Environmental Health Consultation Response

To	Hebe Smith
Date	01-10-2026
Planning Ref	BR/171/26/PL
Site Description	32 London Road Bognor Regis West Sussex PO21 1PY
Date of Application	2026-09-30 00:00:00
Category	Application
Recommendation	No Objection No Objection — with conditions Objection Holding Objection

Planning Response BR-171-26-PL - 32 London Road, Bognor Regis, West Sussex, PO21 1PY

SHEET TITLE
ELEVATIONS AS PROPOSED

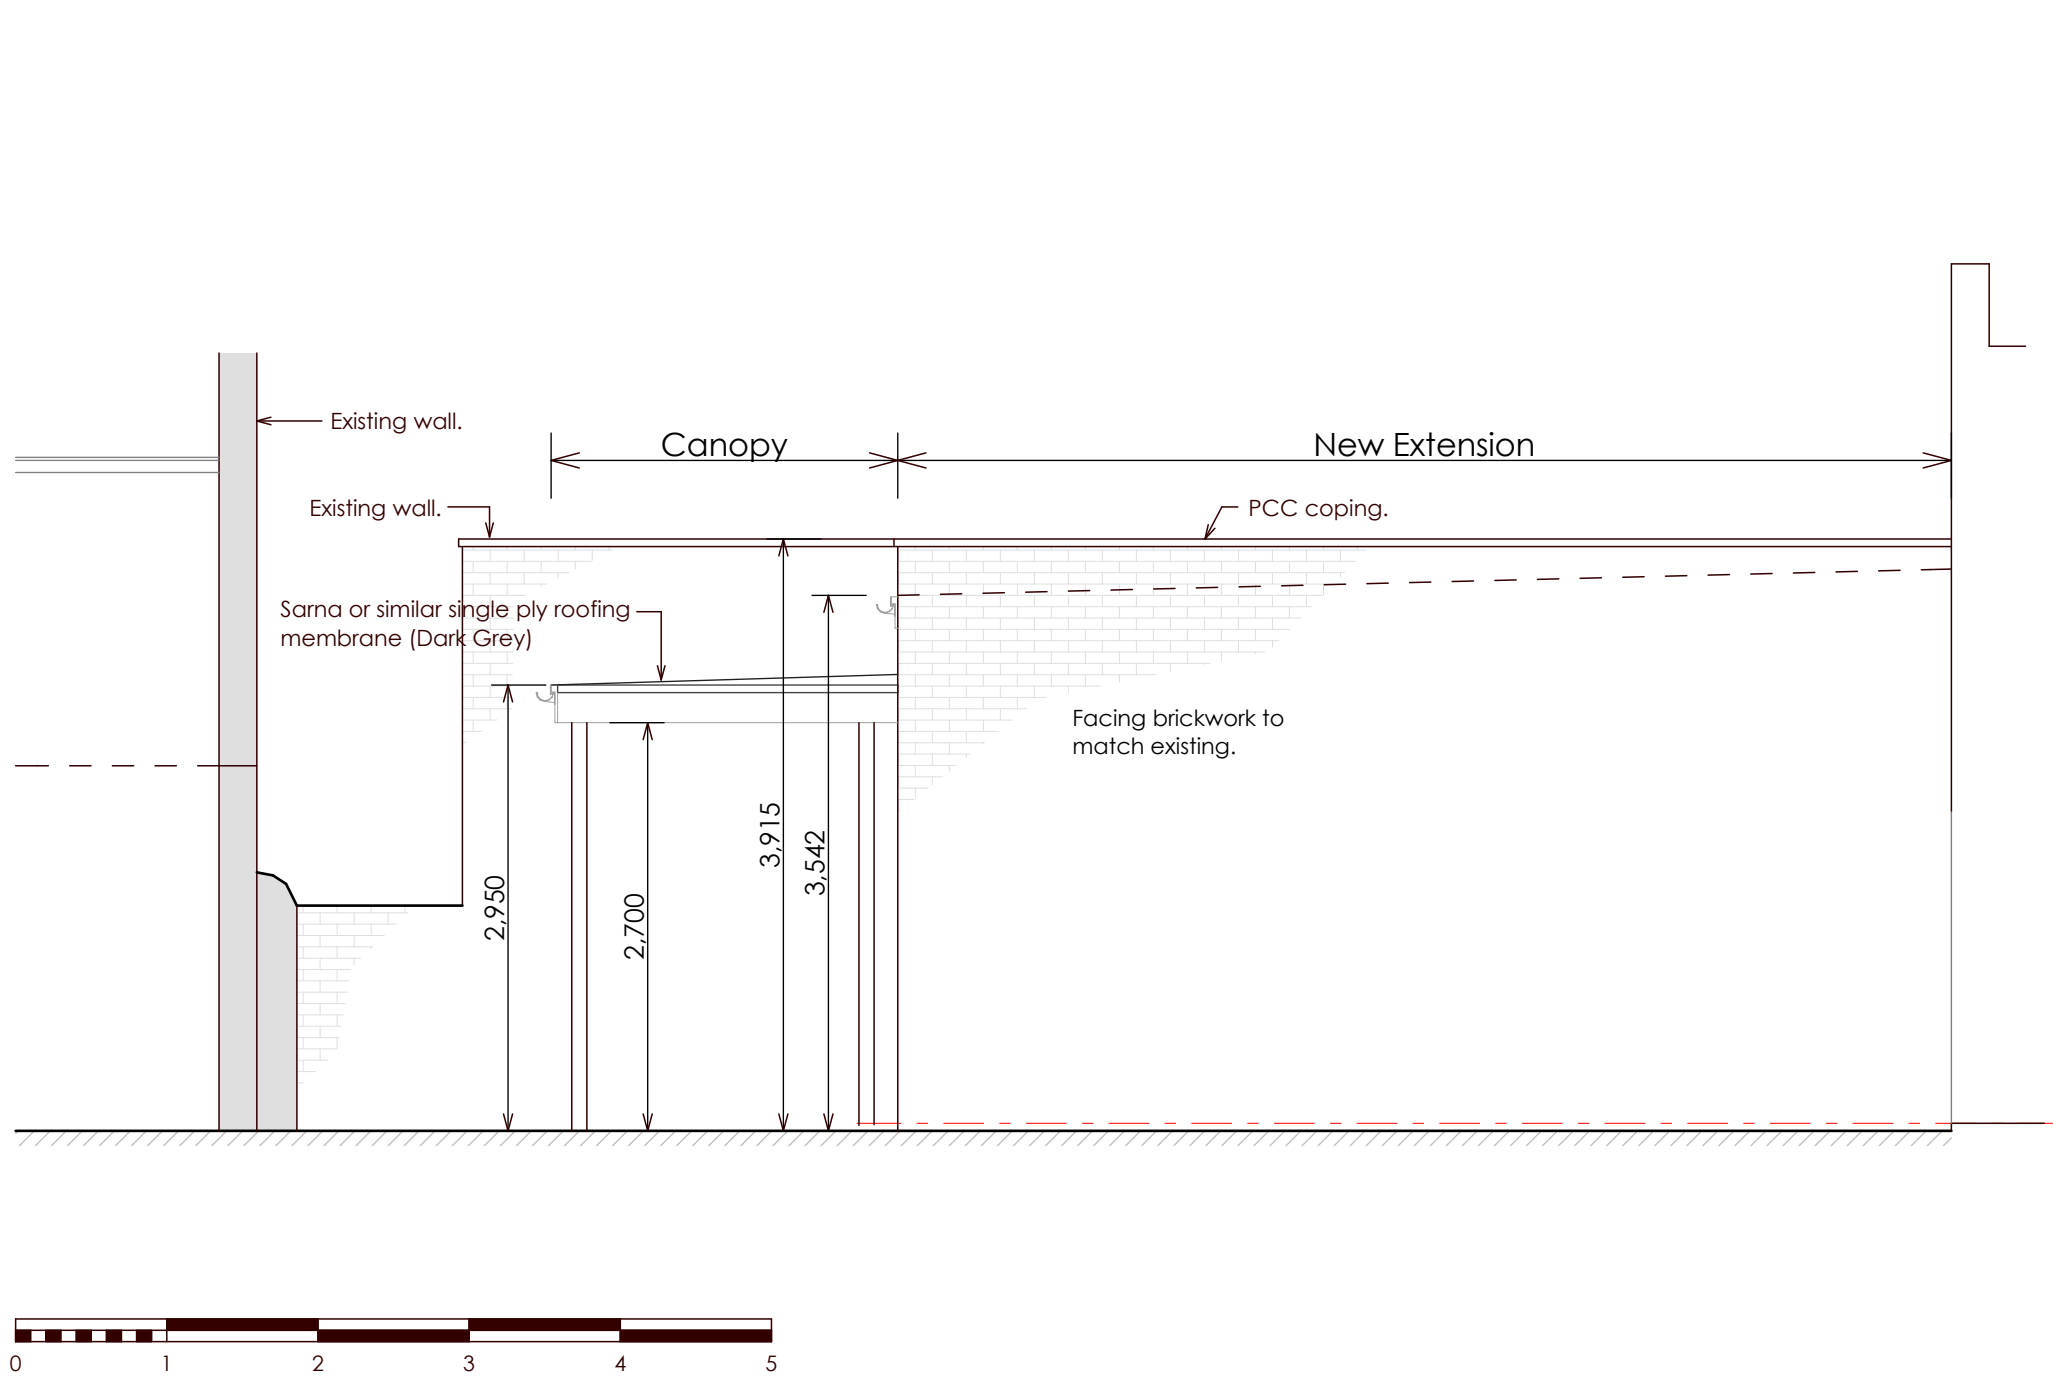
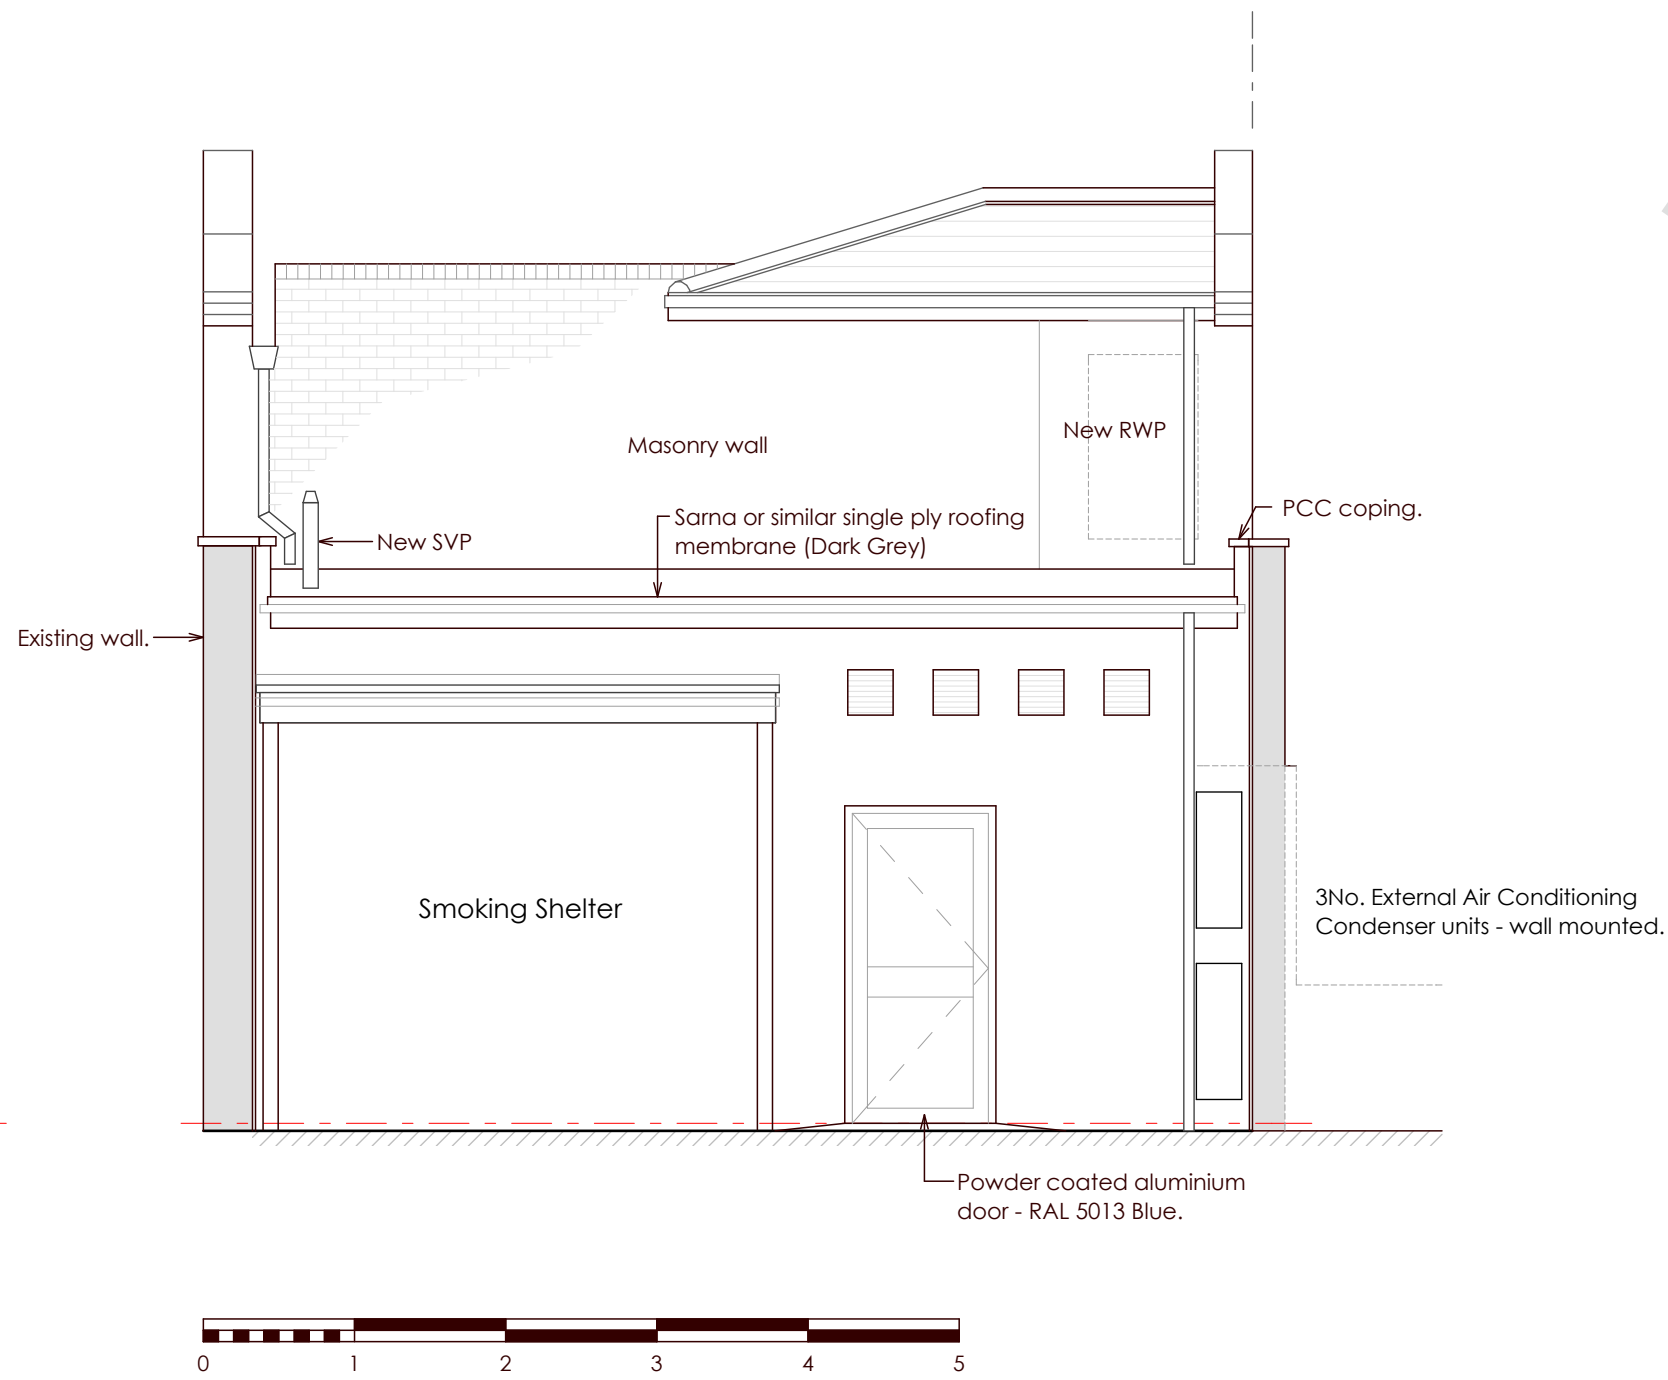
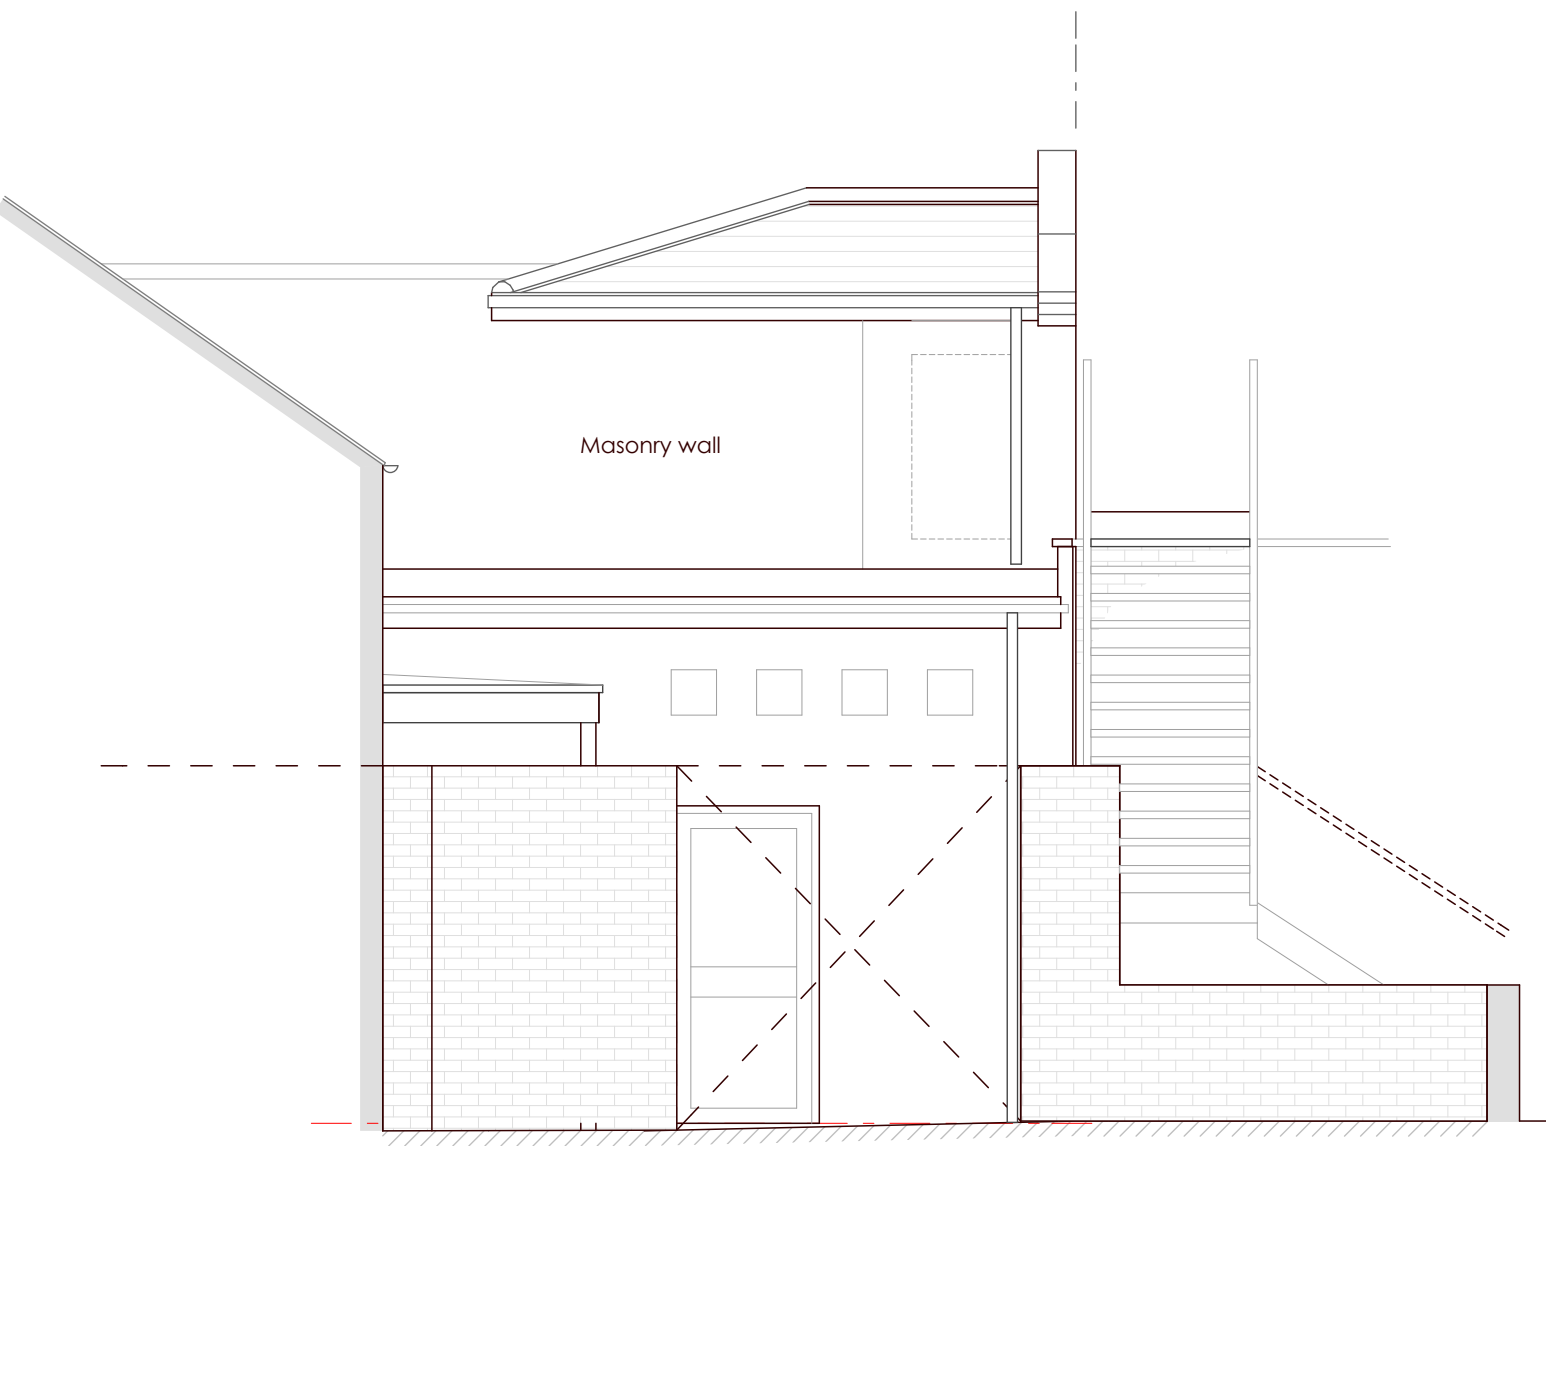
The above application proposes the installation of three air-conditioning units. No acoustic data or noise impact assessment has been submitted and, as a result, it is not possible to predict the rating sound level from the proposed plant or assess the likely impact on nearby noise-sensitive receptors.

Having regard to the location and position of the units, the proposal may be capable of being acceptable; however, this cannot be confirmed without suitable acoustic evidence. A noise impact assessment, prepared by a suitably competent person in accordance with BS 4142:2014+A1:2019, should therefore be submitted.

The assessment should include representative background sound measurements, the cumulative rating level of all three units, any applicable acoustic-feature corrections, an assessment at the nearest noise-sensitive receptors and details of any mitigation required. I would recommend a holding objection until this information is submitted.
